**WELWYN HATFIELD COUNCIL – DEVELOPMENT CONTROL**  
**DELEGATED REPORT**

<b>APPLICATION No:</b>	<b>S6/2011/1999/LU</b>
----------------------------	------------------------

**DESCRIPTION OF PROPOSAL:**

COPYRIGHT: The contents of this drawing may not be reproduced in part or in whole without the written consent of Building Design Consultants	
PROJECT: Proposed extension, loft conversion & alterations	DRAWING NUMBER: 10015/3

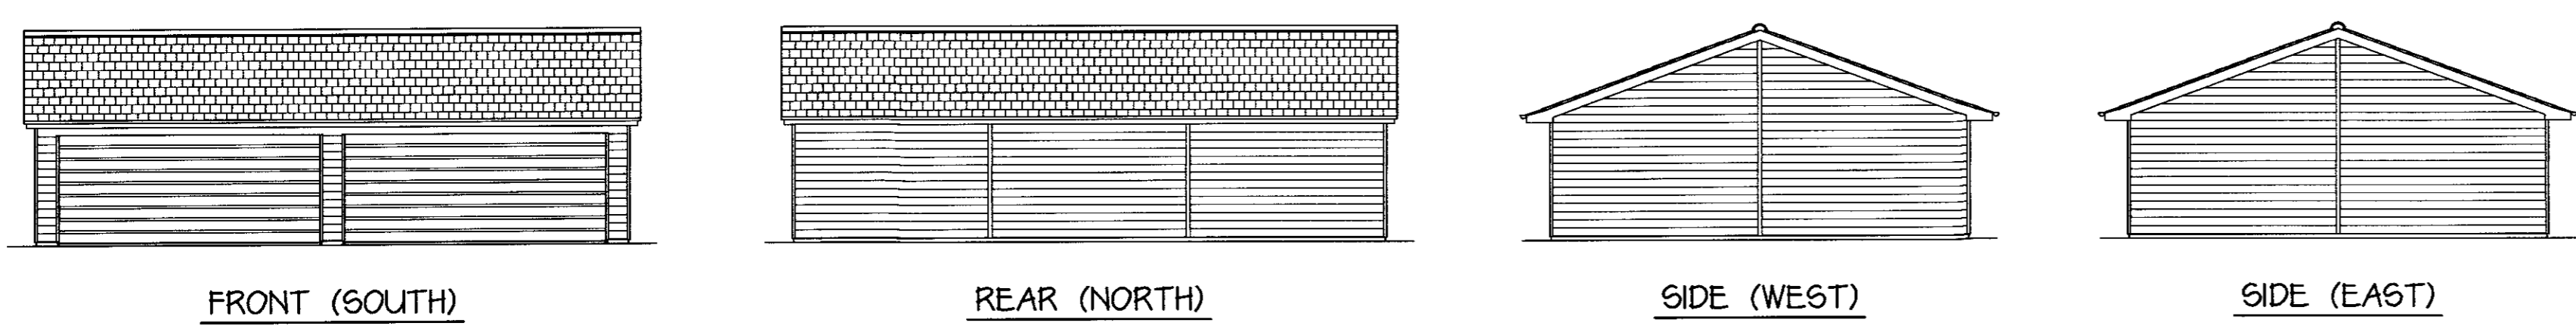
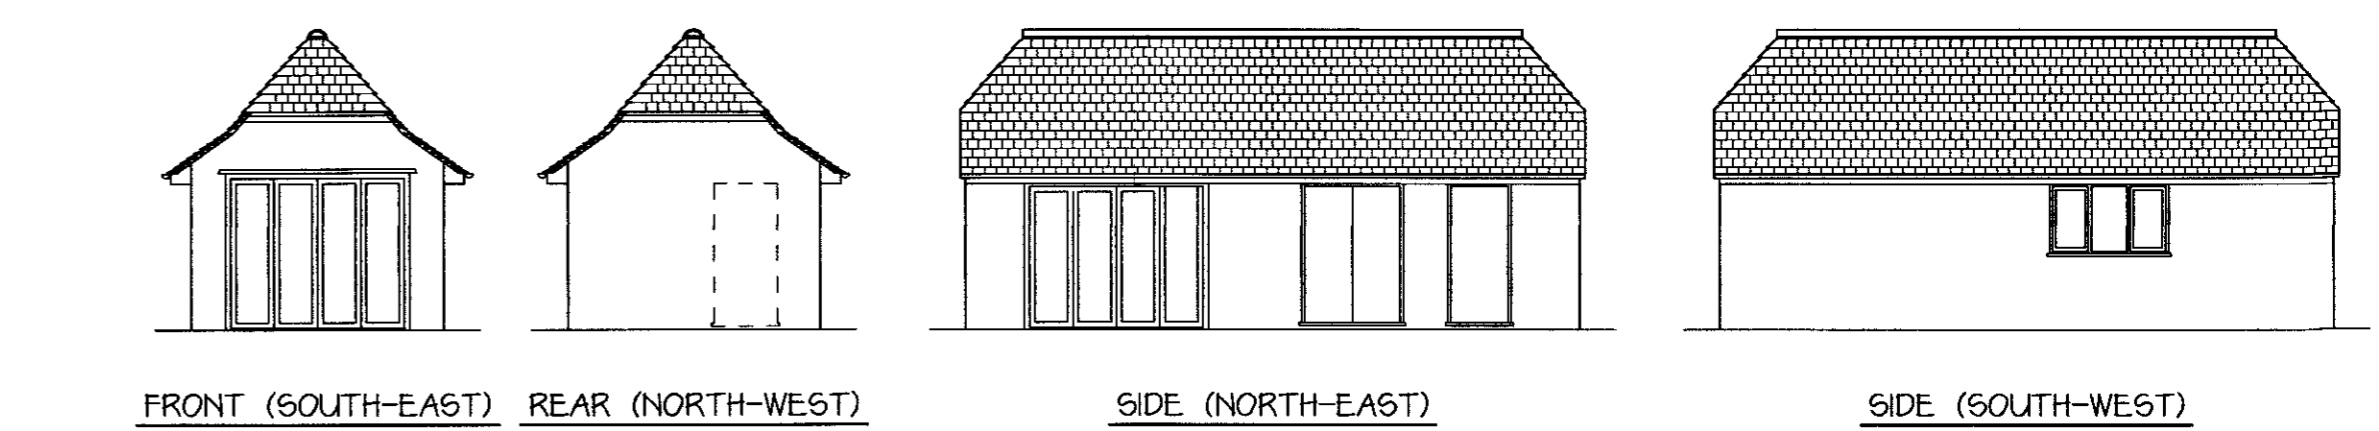
Along the south western extent of the parcel of land containing the dwellinghouse is fencing which further seeks to separate the parcels of land. Evidence has not been put before me which suggests that the parcel of land to the rear can be considered as part of the residential curtilage taking into consideration the above. Whilst the stables have ceased use, the two parcels of land in question remain defined by existing boundary treatments and it is considered that the parcel of land to the rear does not constitute part of the residential curtilage. Therefore, the proposed extension and conversion of the existing stable block to a double garage cannot be considered under permitted development.

DRAWING: Location plan

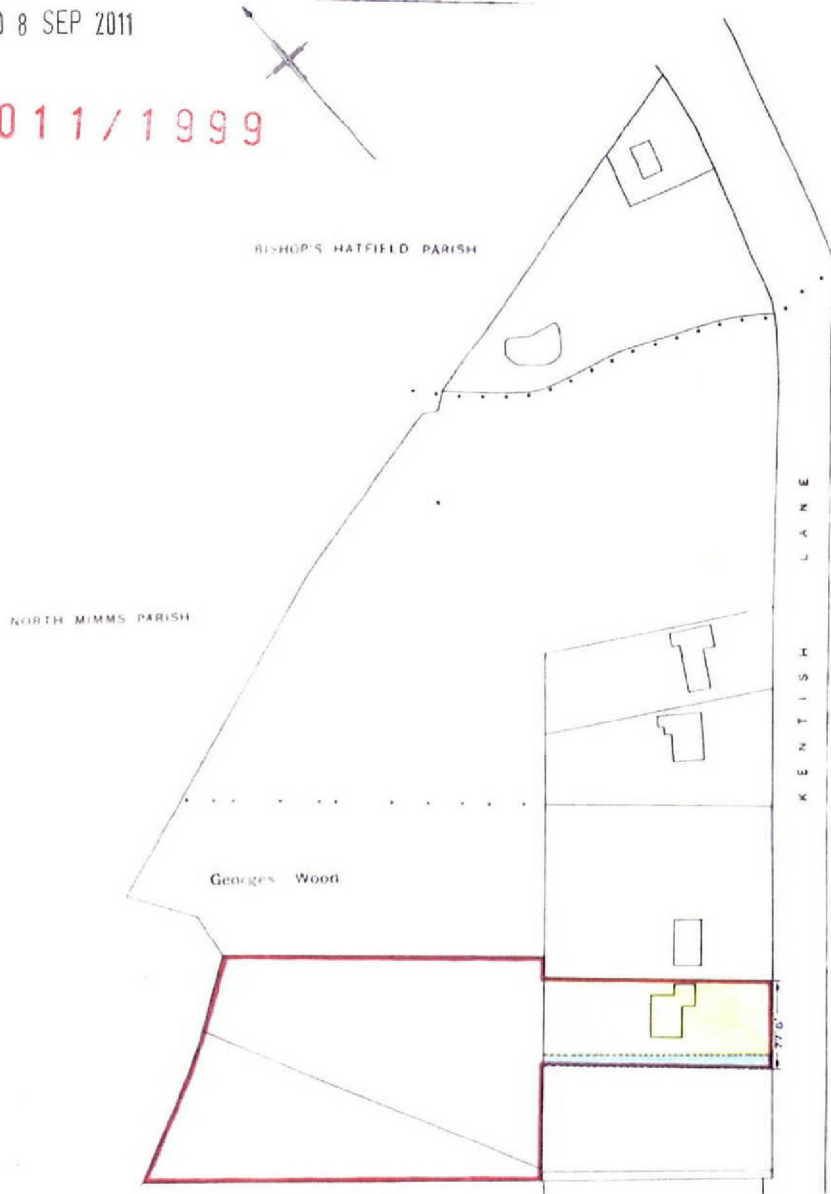
The red outline on the submitted Site Location Plan (1:1250) is shown to be the land containing the dwellinghouse and land to the rear of the dwellinghouse containing the existing stable block. The parcel of land to the south west of the dwellinghouse is outlined in blue which is in the ownership of the applicant but is not considered by the applicant to be the residential curtilage of the dwellinghouse.
